RE: Rudino's Cameron

A plan review was received by this office concerning the construction of the above referenced facility. The plans are not approved at this time with the following comments:

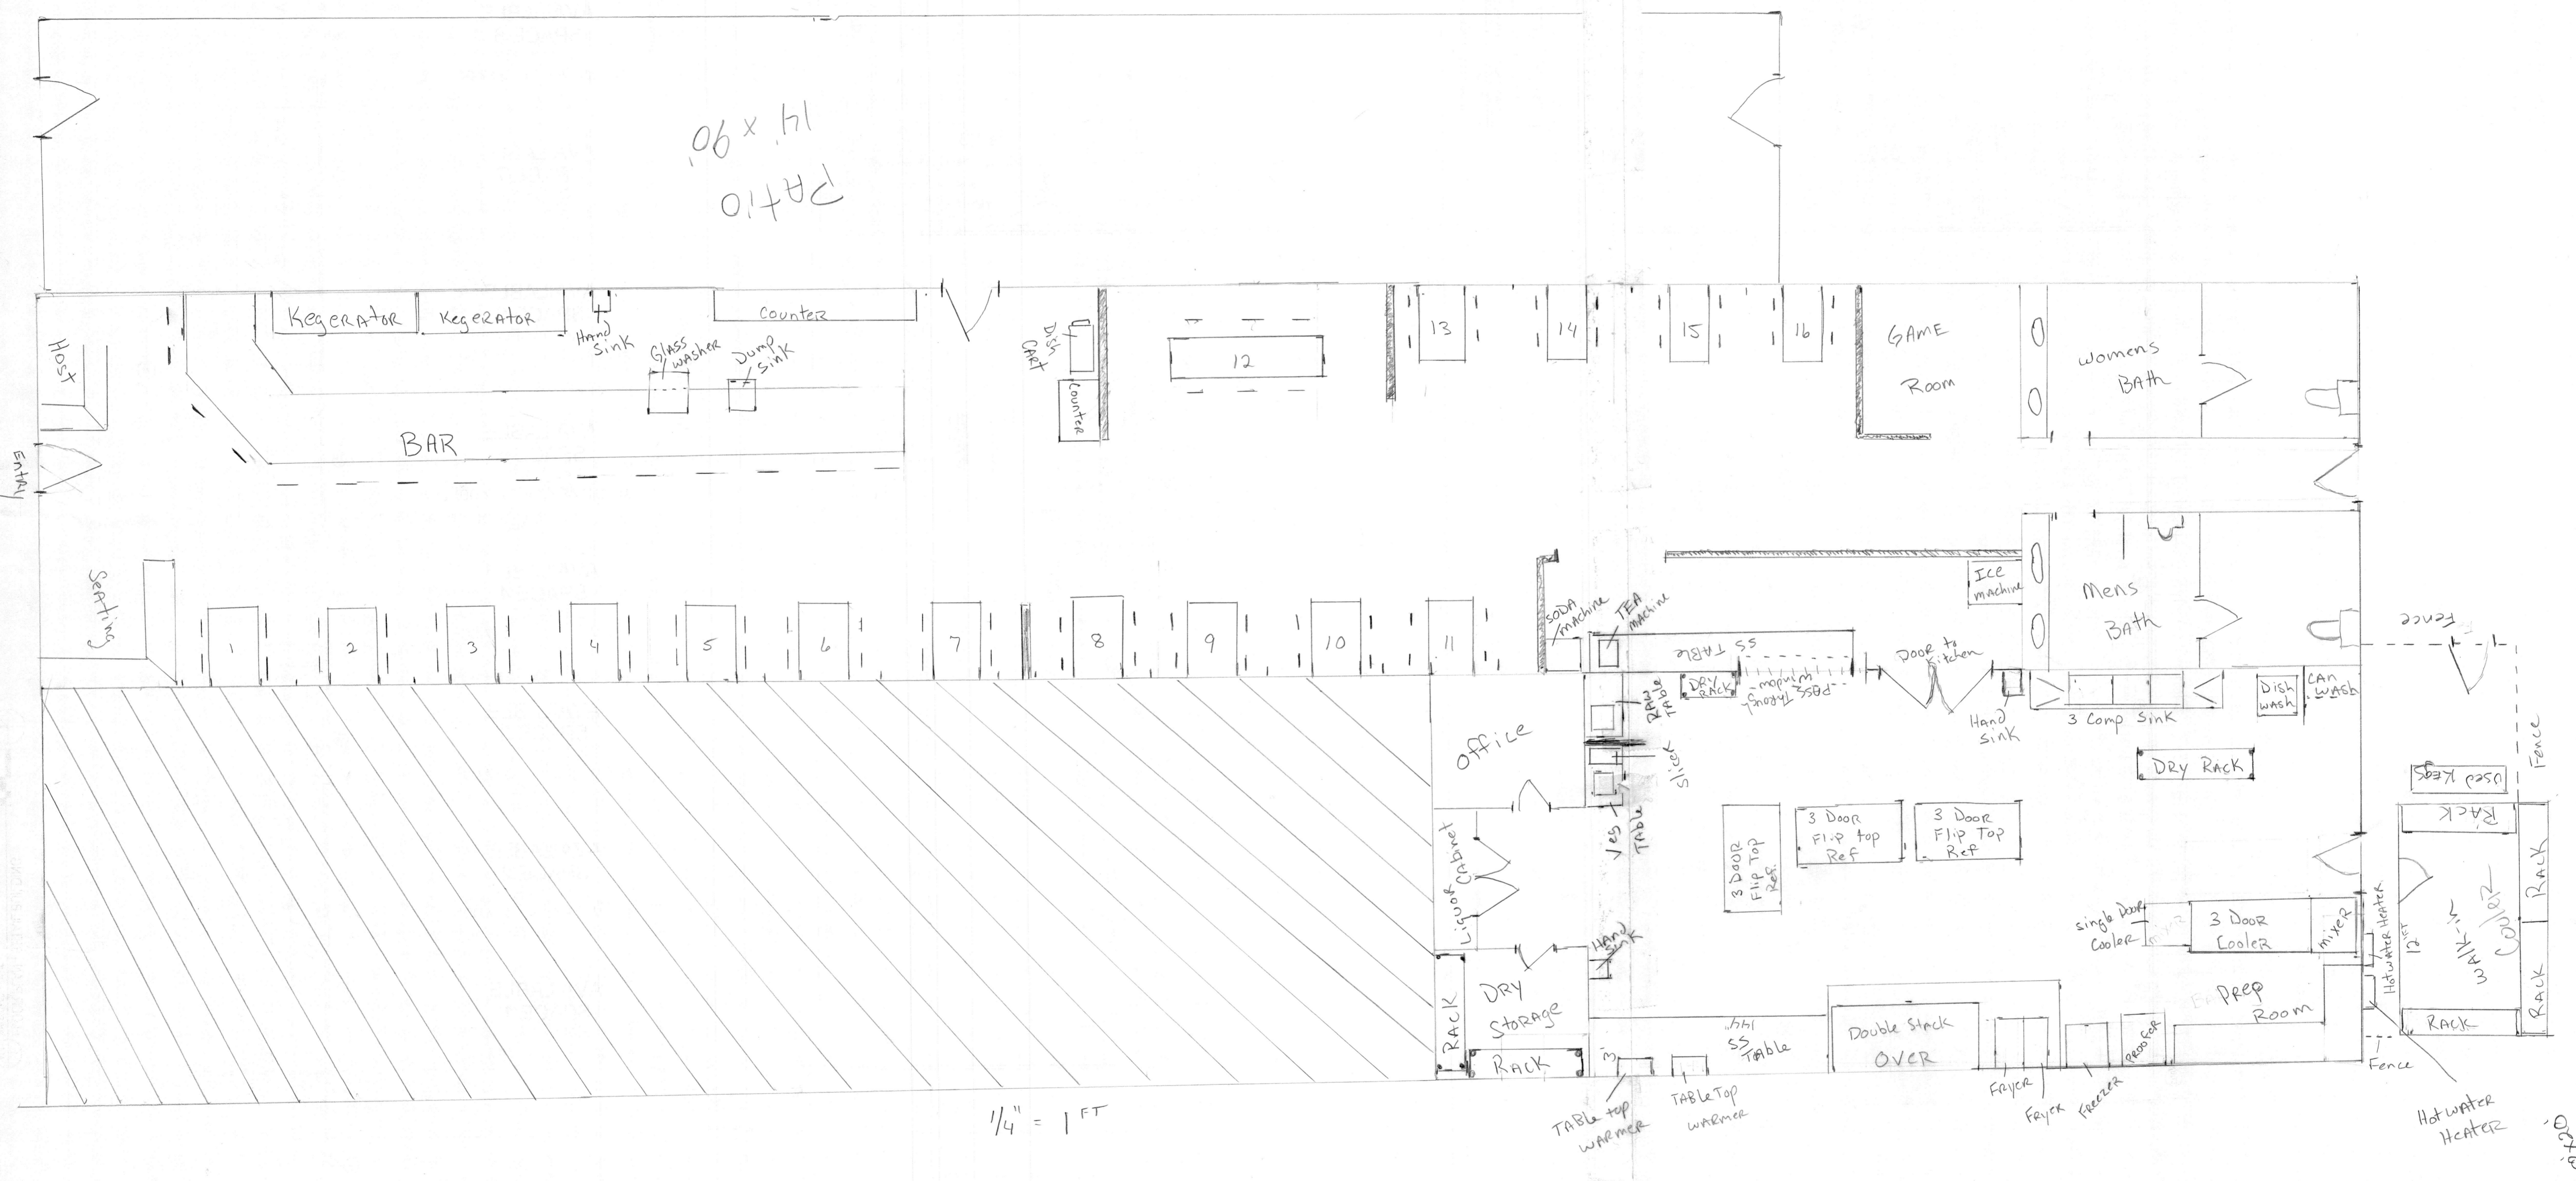
- The specification sheets include a chef base with countertop griddle. This item is not included on the floor plan most recently submitted. If this item is still intended to be used please indicate placement.

- Identify the L shaped apparatus in the corner of the area labeled 'prep room'.
- There appears to be a splashguard (as would be required) between the prep sinks. Please indicate material of construction and method of attachment.

- No raceways appear to be provided for dish machine. Please indicate location and placement and submit specification sheets for raceways.
- The location as shown of the large mixer is in close proximity to the rear entry door. Access to the mixer also appears to be partially blocked on both sides by the three door cooler and what comprises the L shaped apparatus. It is recommended that the mixer be relocated to allow for easier access and to preclude any potential contamination from exposure to rear entry.

- Any items added or relocated should be noted on an updated floor plan.
